From: Mark Warwick <Mark.Warwick@arun.gov.uk>

Subject: RE: WA/7/19/RES - Lanes End, West Walberton Lane - Additional information request

PJ DEVELOPMENTS LTD 2 Square Chambers 23 High Street Emsworth PO10 7AQ Tel: 0843 289 3430 Email: enquiries@pjdevelopmentsltd.com	
PROJECT: FORMER LANES END	
SITE PLAN OUTLINE PLANNING APPLICATION	
DATE: JANUARY 2019	DWG. NO 19-001 PL02
SCALE @ A1: 1:200	
REV: C

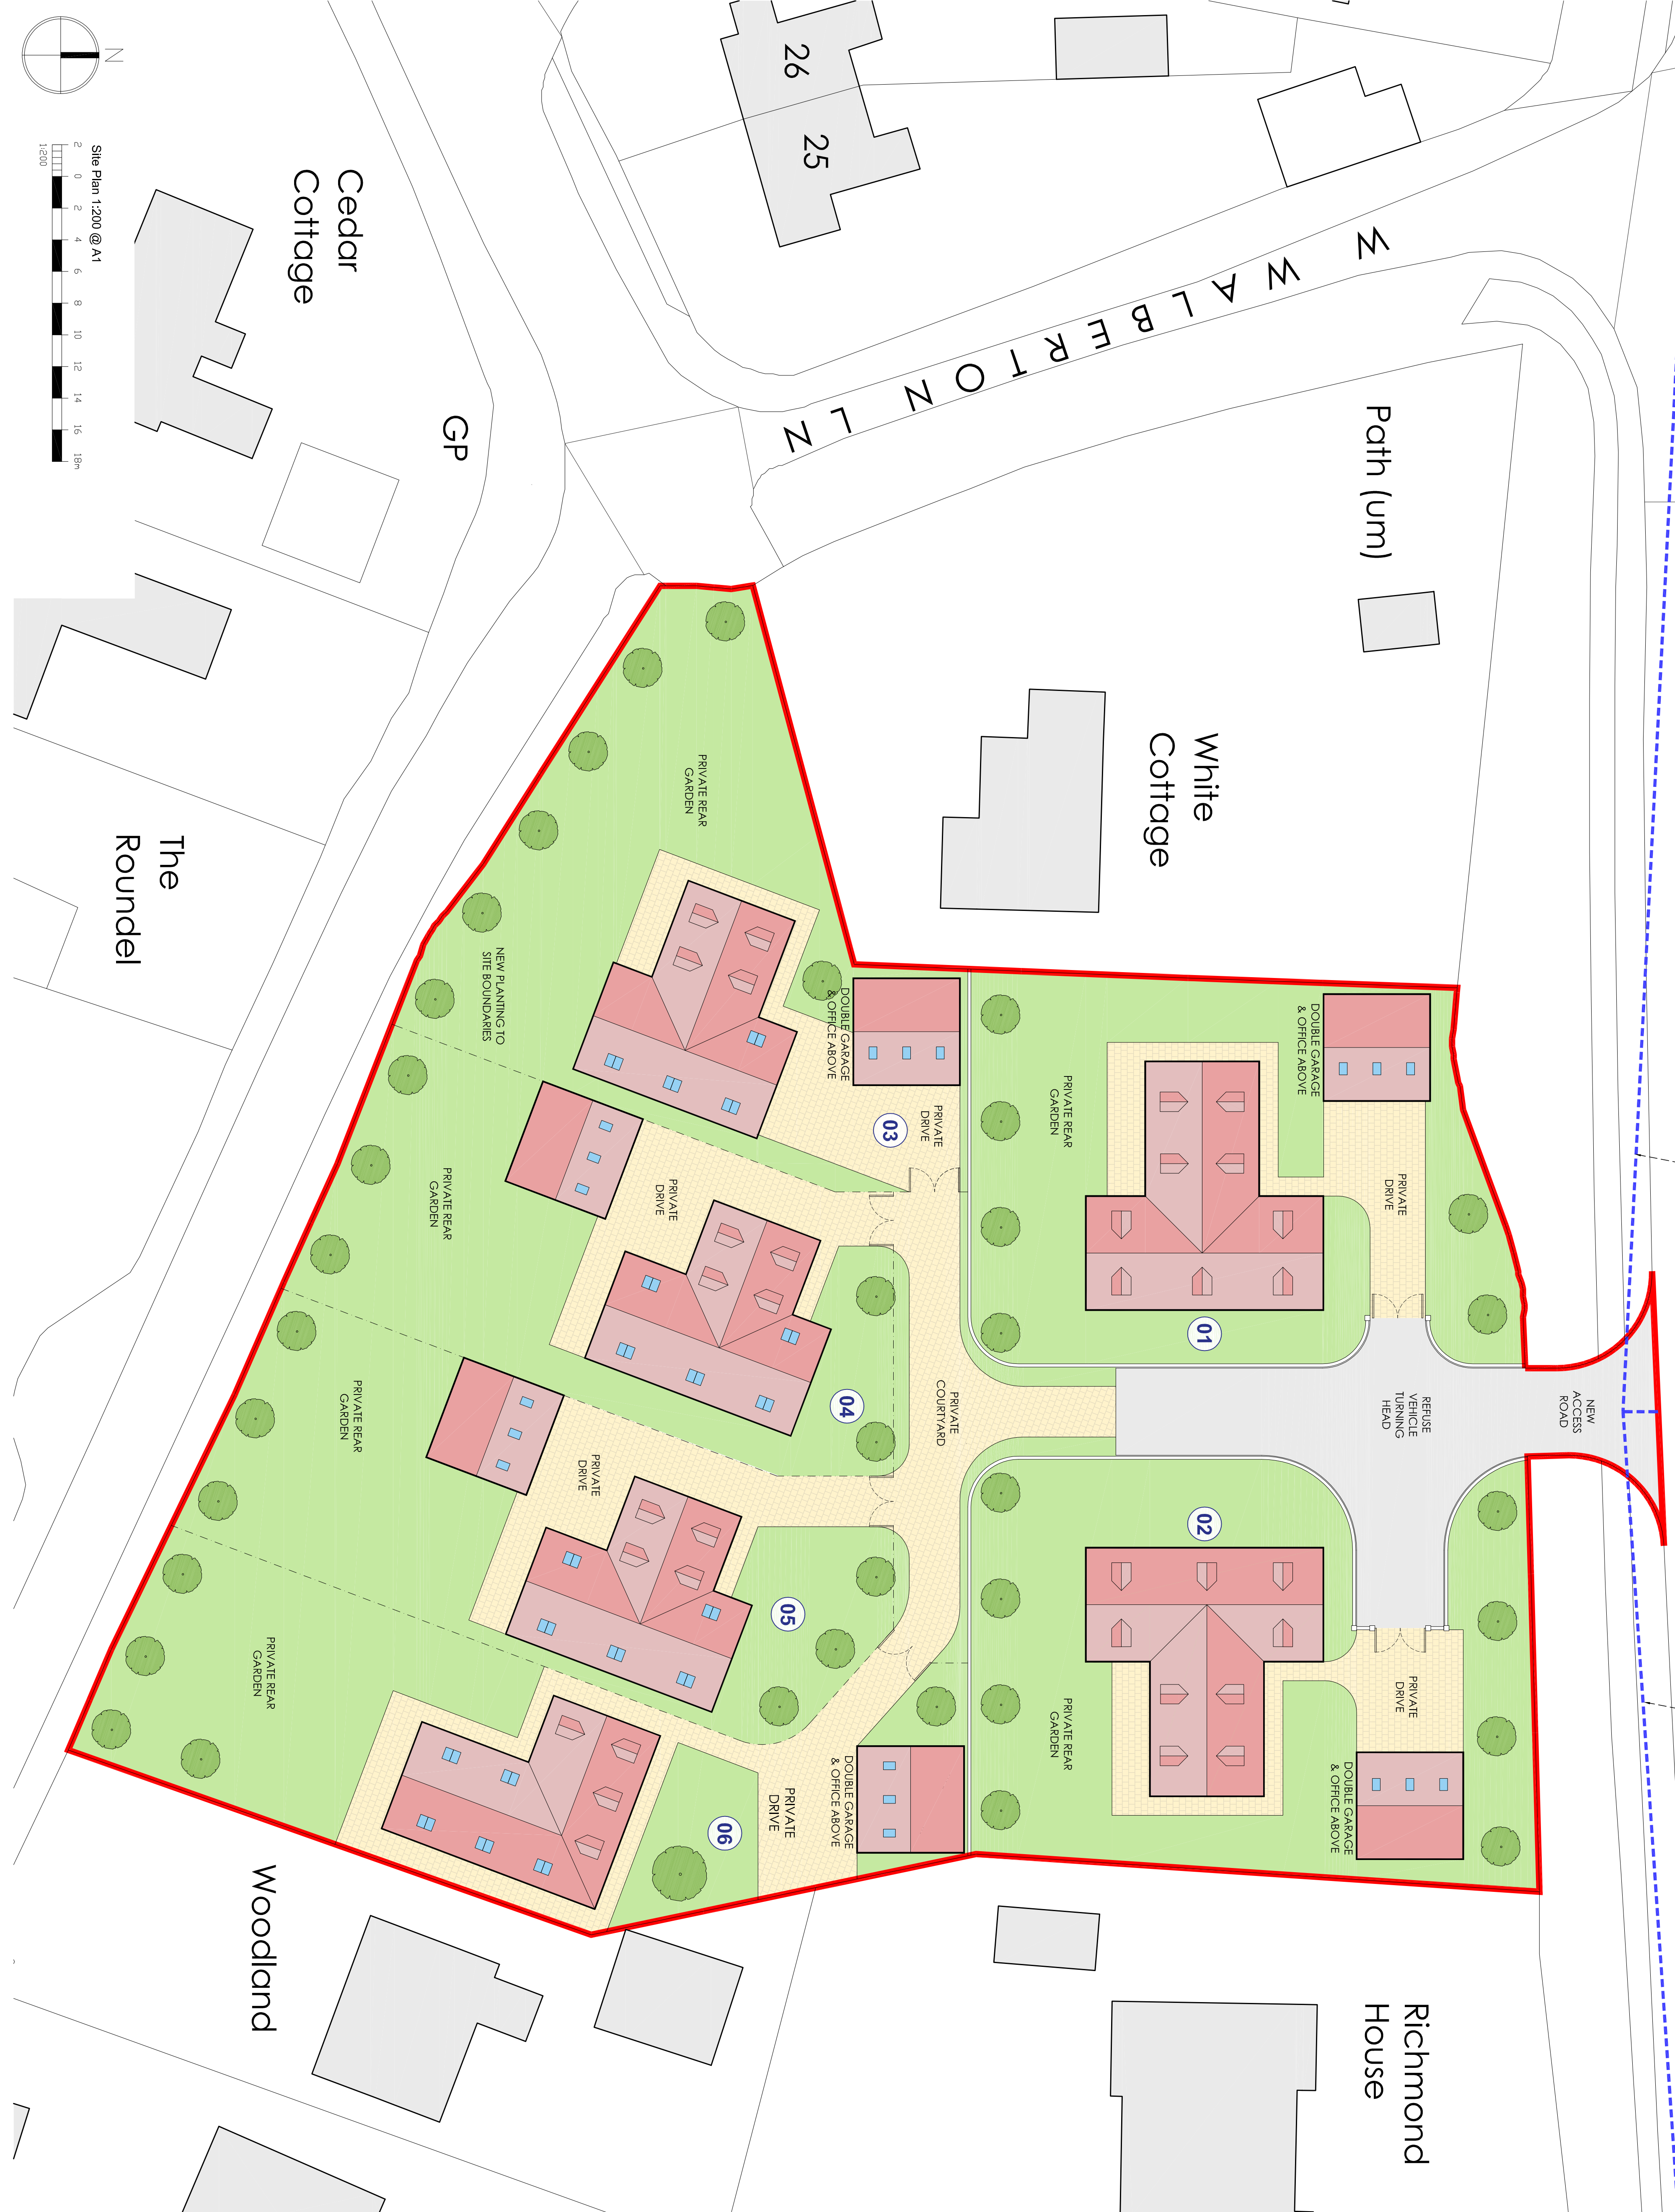
1. Amend the layout to ensure that a minimum of 9 metres exists on from blank gable end (or obscure glazed windows non opening below 1.7 metres in height) of nearest proposed house to gable end of 'Woodlands' which currently incorporates sole habitable room windows.
2. Remove second storey of houses/rooms in roof. 3 storey townhouses would not be acceptable in this location

1, Happy to amend property six to make a nine metre distance.

DATE:	DWG.
APRIL 2019	NO
SCALE @ A1:	
1:1:100	19-001
REV:	PL05
A

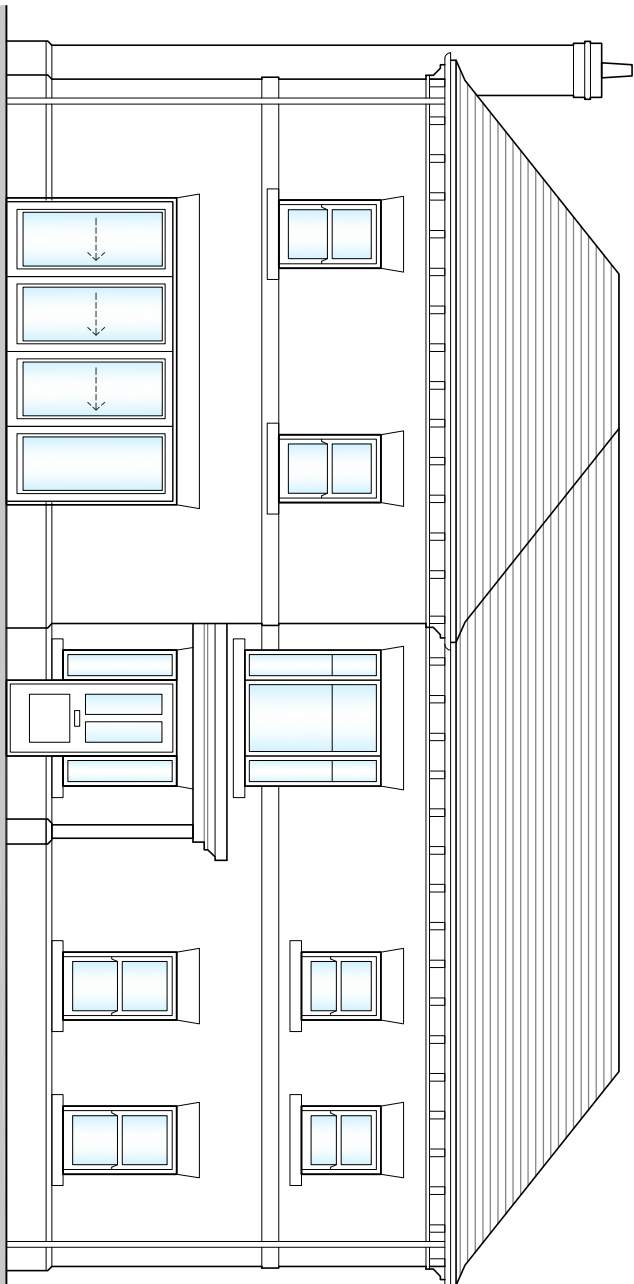
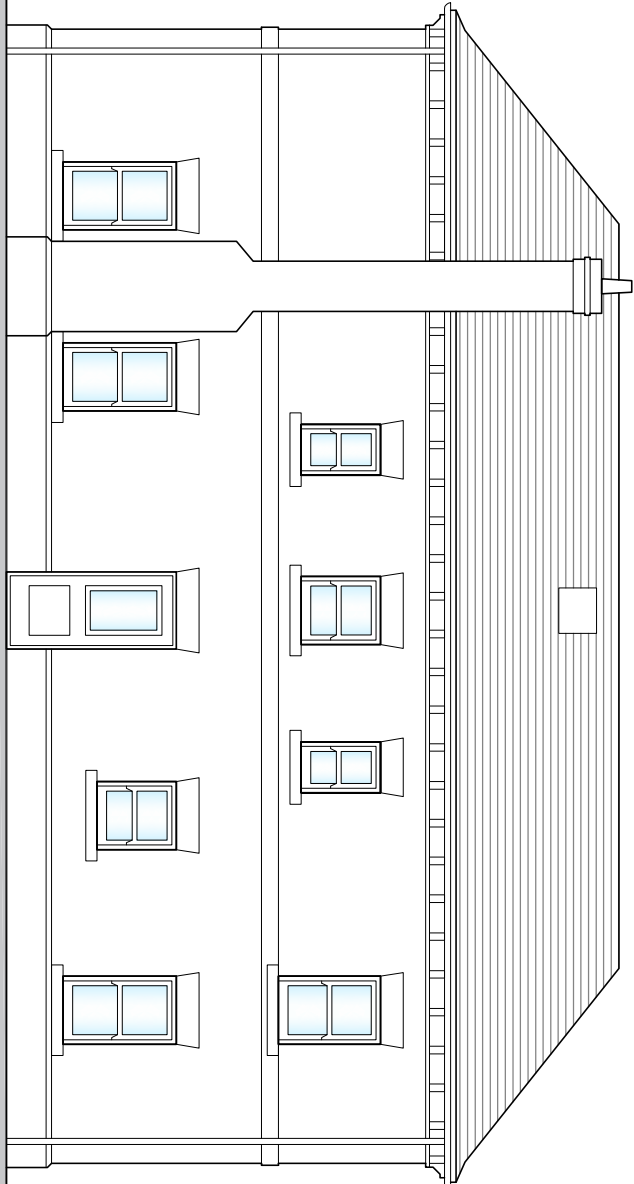
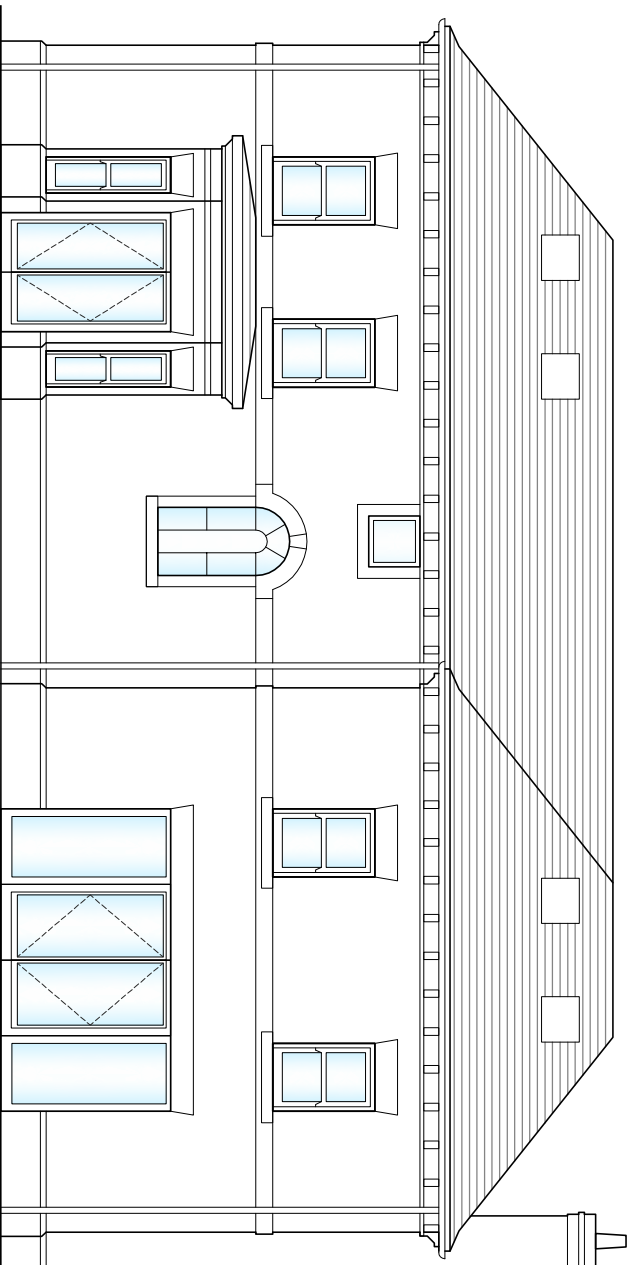
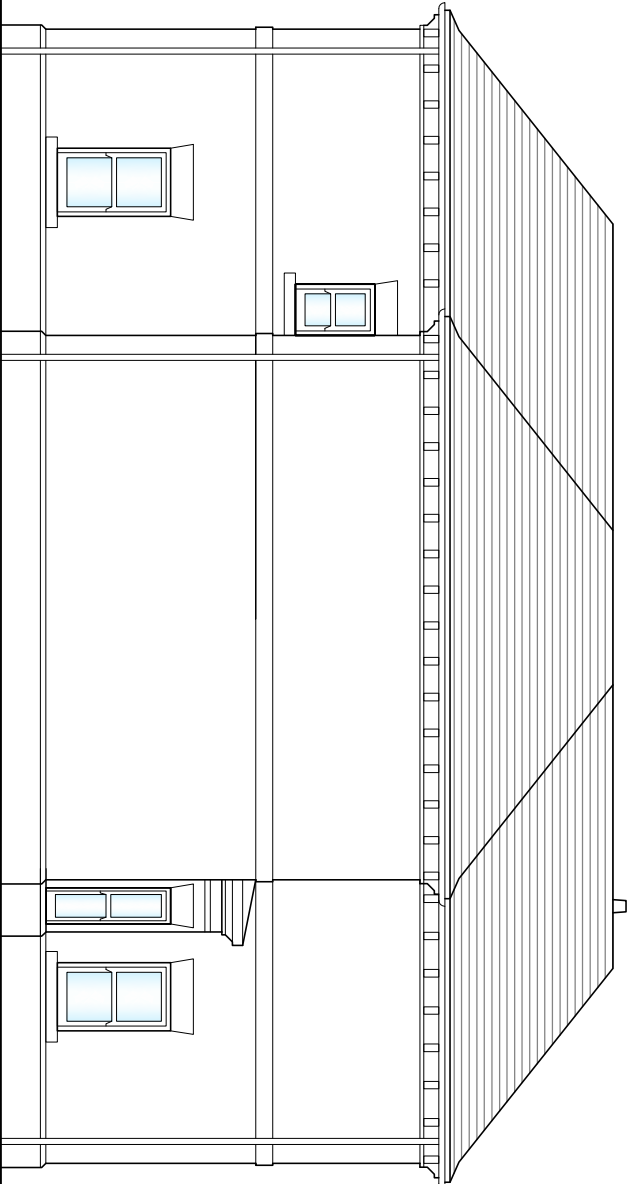
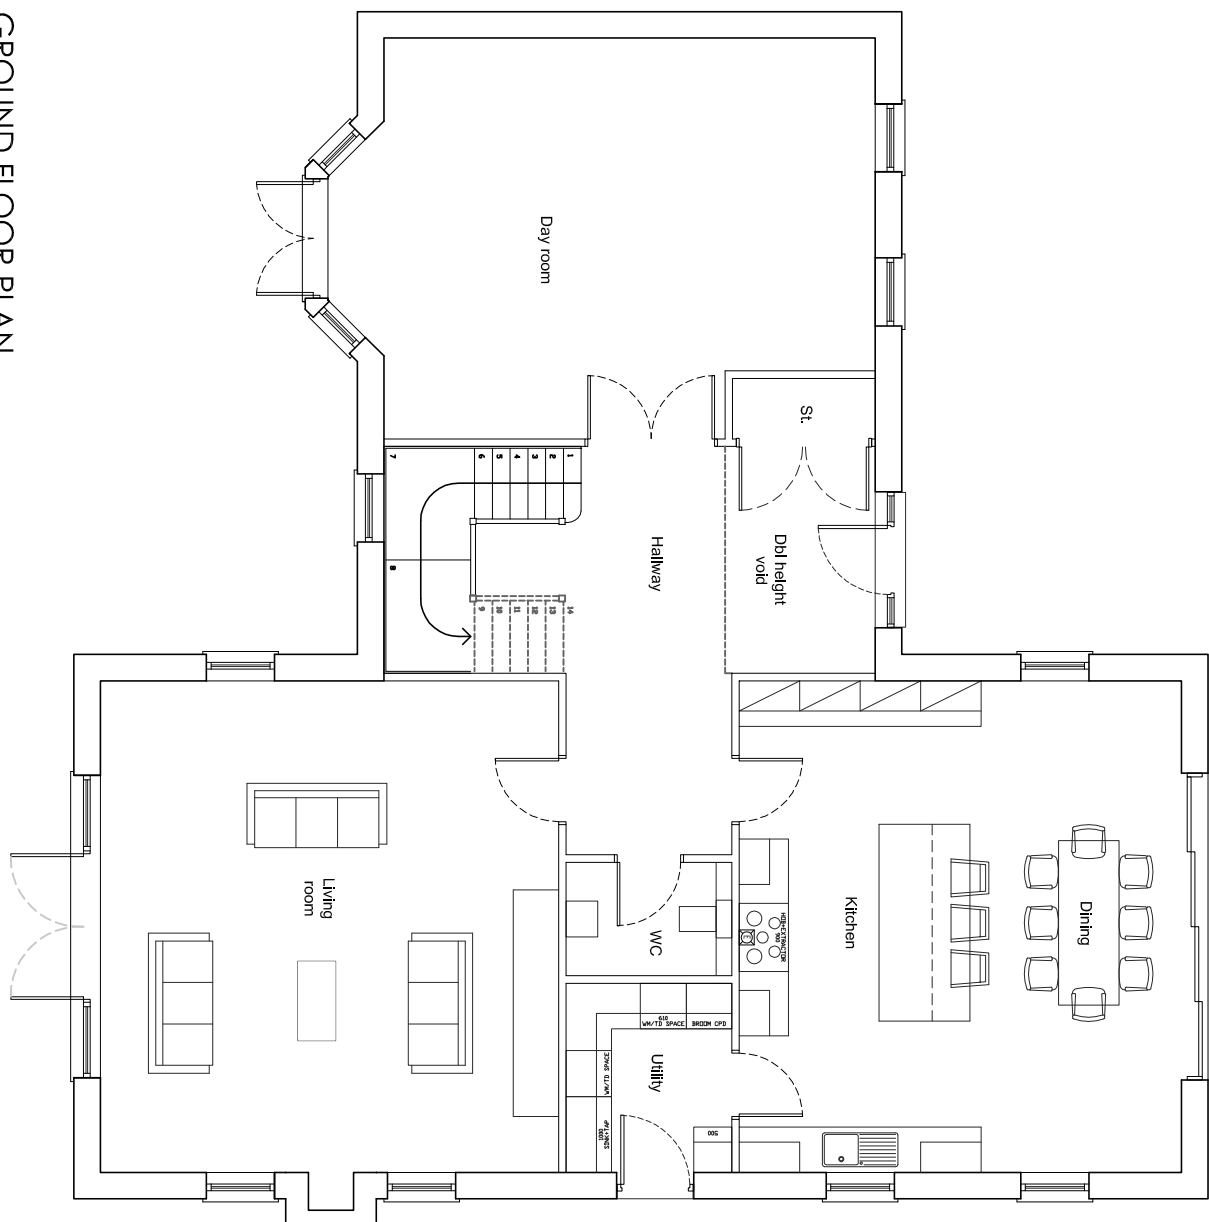
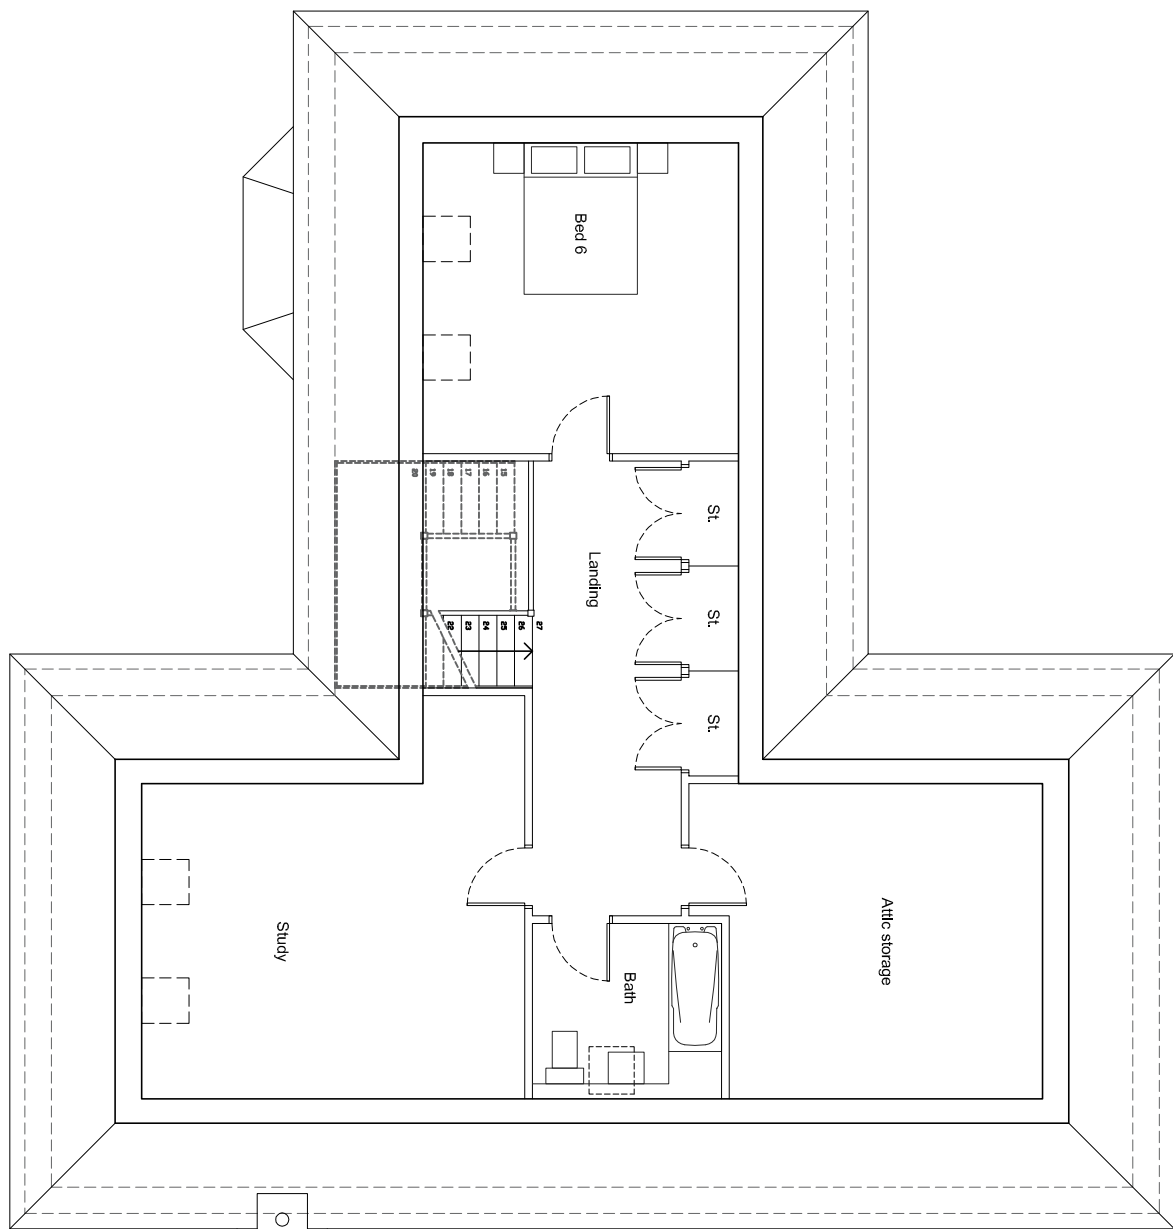
the issue with the rooms in the roof is that the appearance of the dwellings will be of a town house which is simply not appropriate in this location. I would strongly advise you to remove this element from the scheme. To avoid the risk of the development being viewed as 'out of character' in the area and contrary to policy D DM1 of the Arun Local Plan. I have discussed the matter with my line management team and everyone is of the same view in this case.

2, we fail to see the merit in removing the room in the roof, this would have no impact on the height of the buildings and would result in empty lift spaces which would not allow for good use of space as per the NPPF. You will note from drawing 19-001-PL-03 all the dormers on houses 3-6 are in the south and therefore can not be seen from the front or any point outside the properties. Currently prosperities one and two have the dormers on the north but I would be happy to move these to the south so these are the same and none can be seen from Arundel road. I also would like to mention the design of white cottage next door that will have dormers in the roof and Richmond house which has velum windows in the roof. As previously mentioned the new ridge heights will be lower than the current house at Lanes end this can be seen in the scale drawings provided. If you could let me know if this is acceptable as if possible to avoid I would prefer not to have to appeal the reserved matters for this small item.
